## EL PASO COUNTY GRADING AND EROSION CONTROL PLAN CHECKLIST

EPC Project Number: PPR-21-023

1 INITIAL GESC PLAN  
 C012

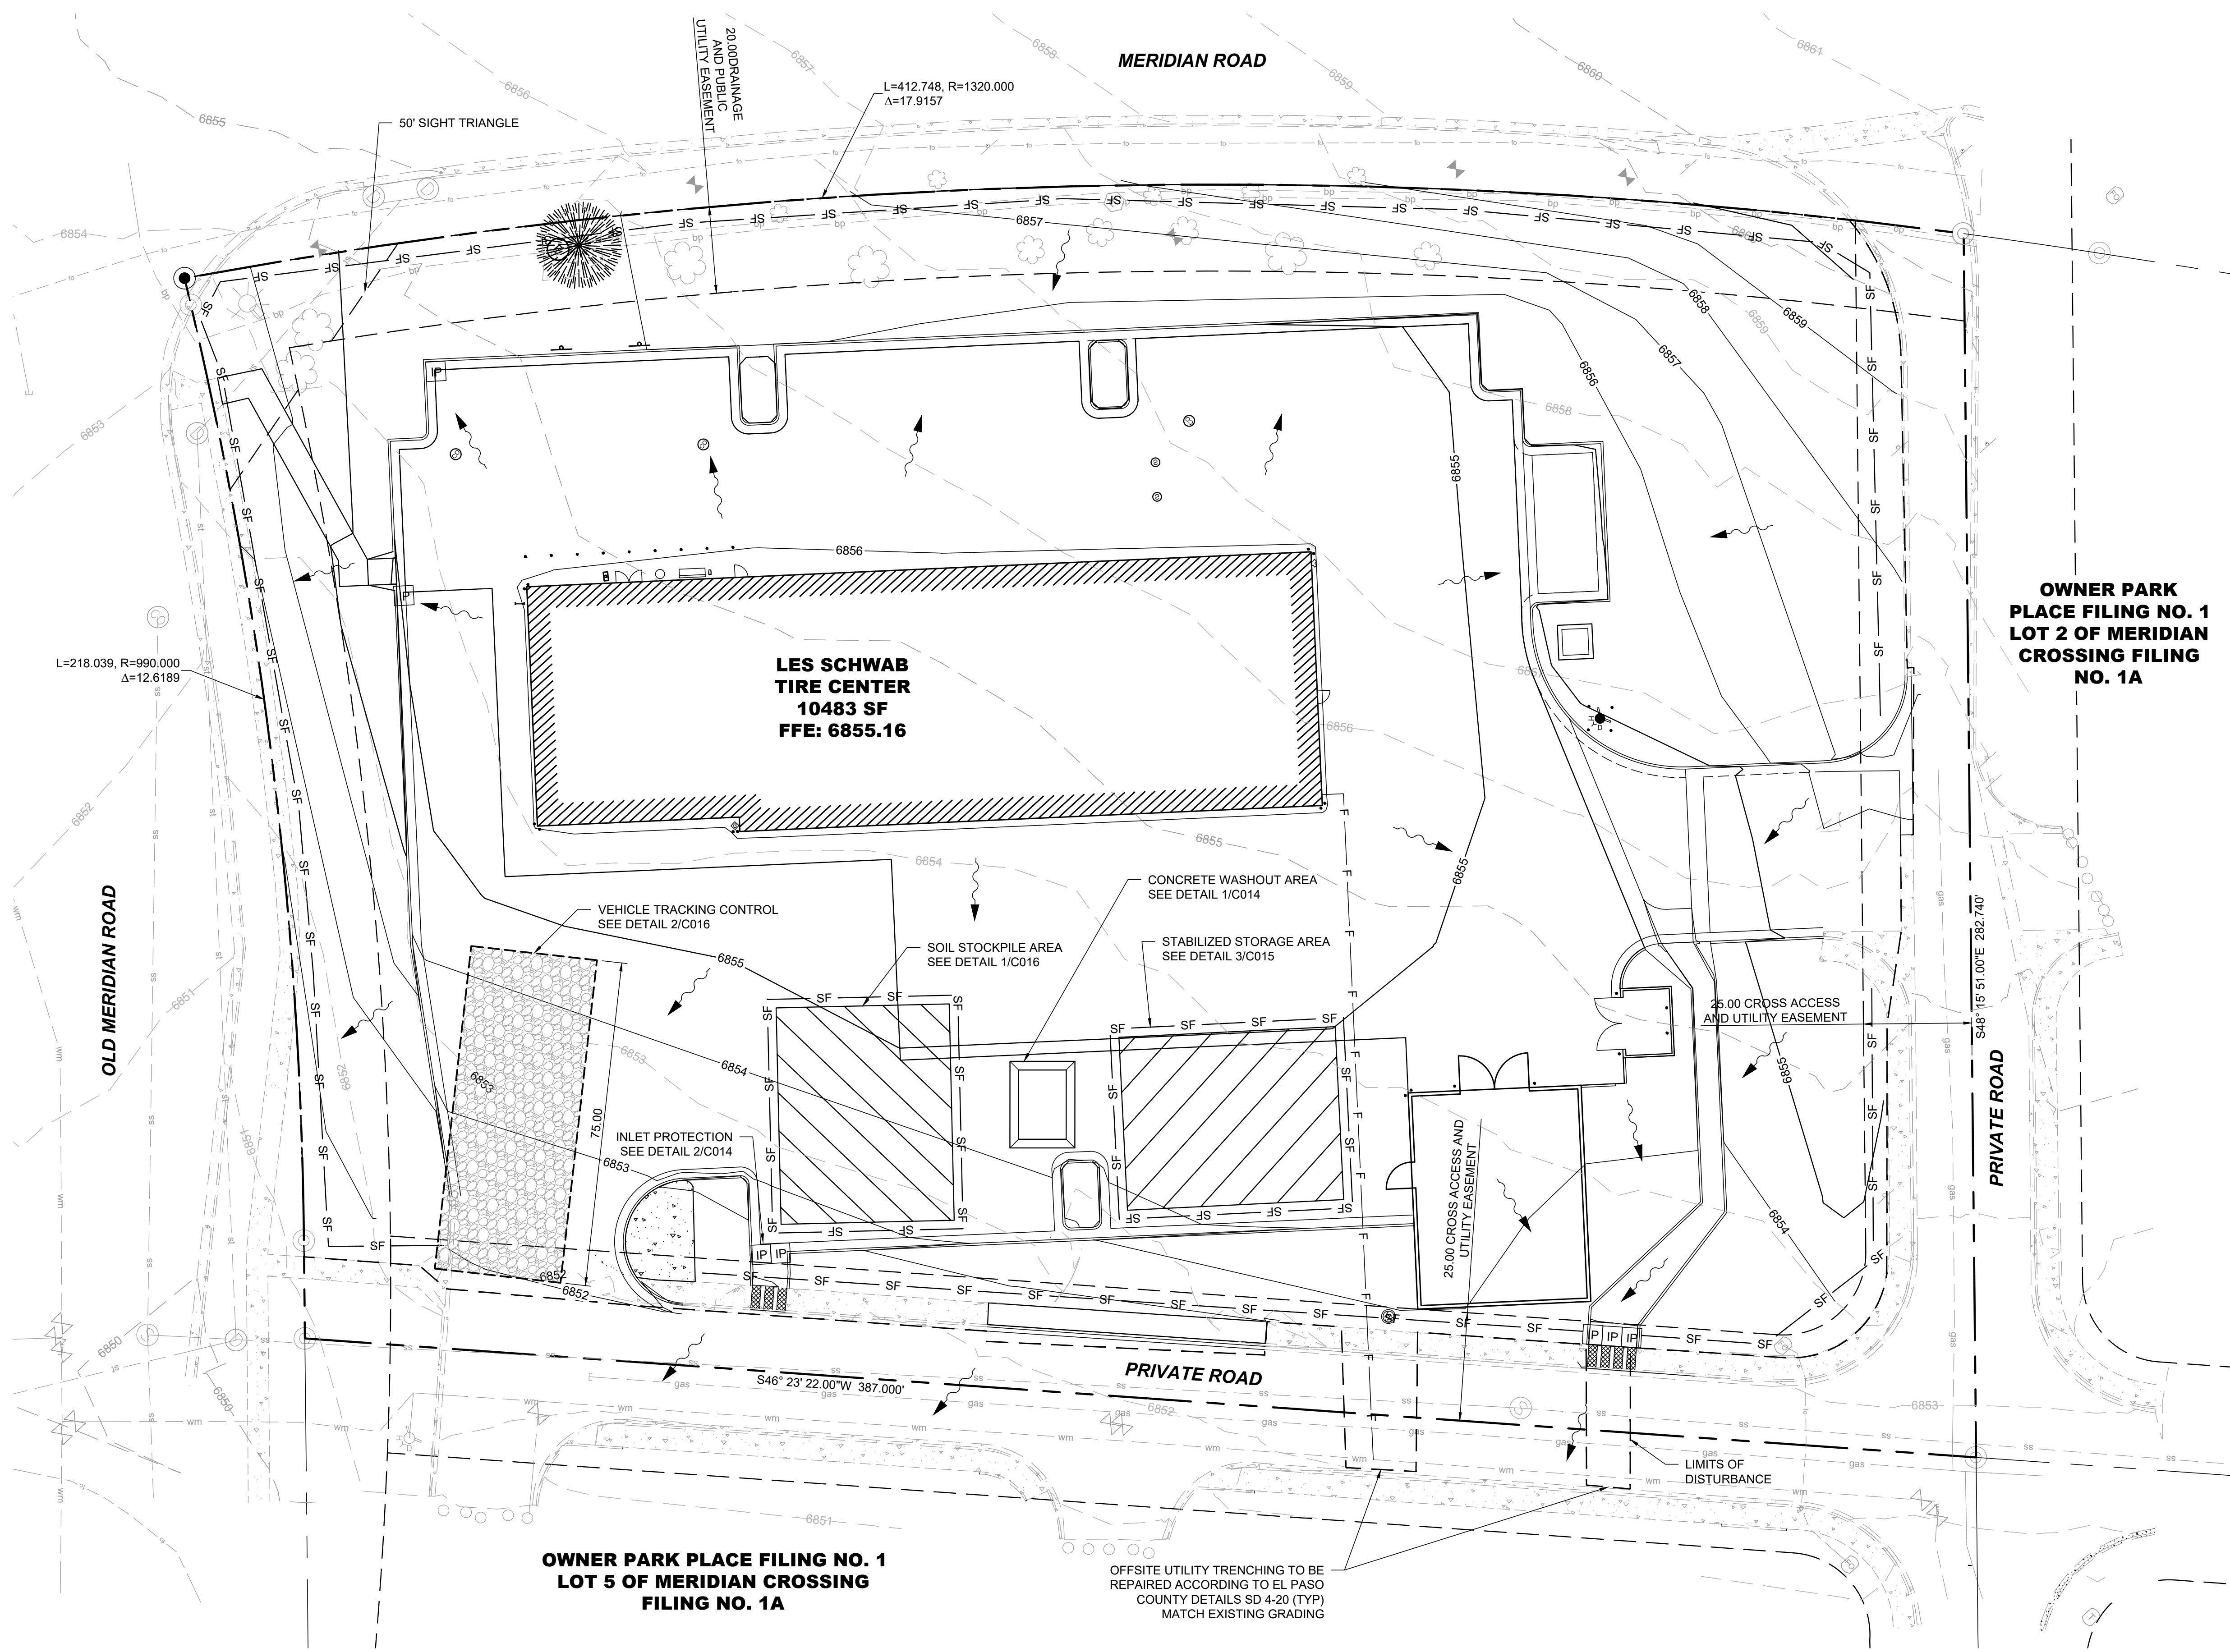
Revise this statement. How it is currently written is not a sufficient reason for not having a TSB. Just because flows will follow historic paths does not mean that runoff isn't full of sediment and in need of treatment. Just say something like: TSB's are not needed because other proposed temporary BMP's are sufficient to minimize/reduce sediment loading in runoff. Also there is not one design point that has much more than 1ac of runoff tributary to it (which is the threshold for needing a TSB, according to our criteria).
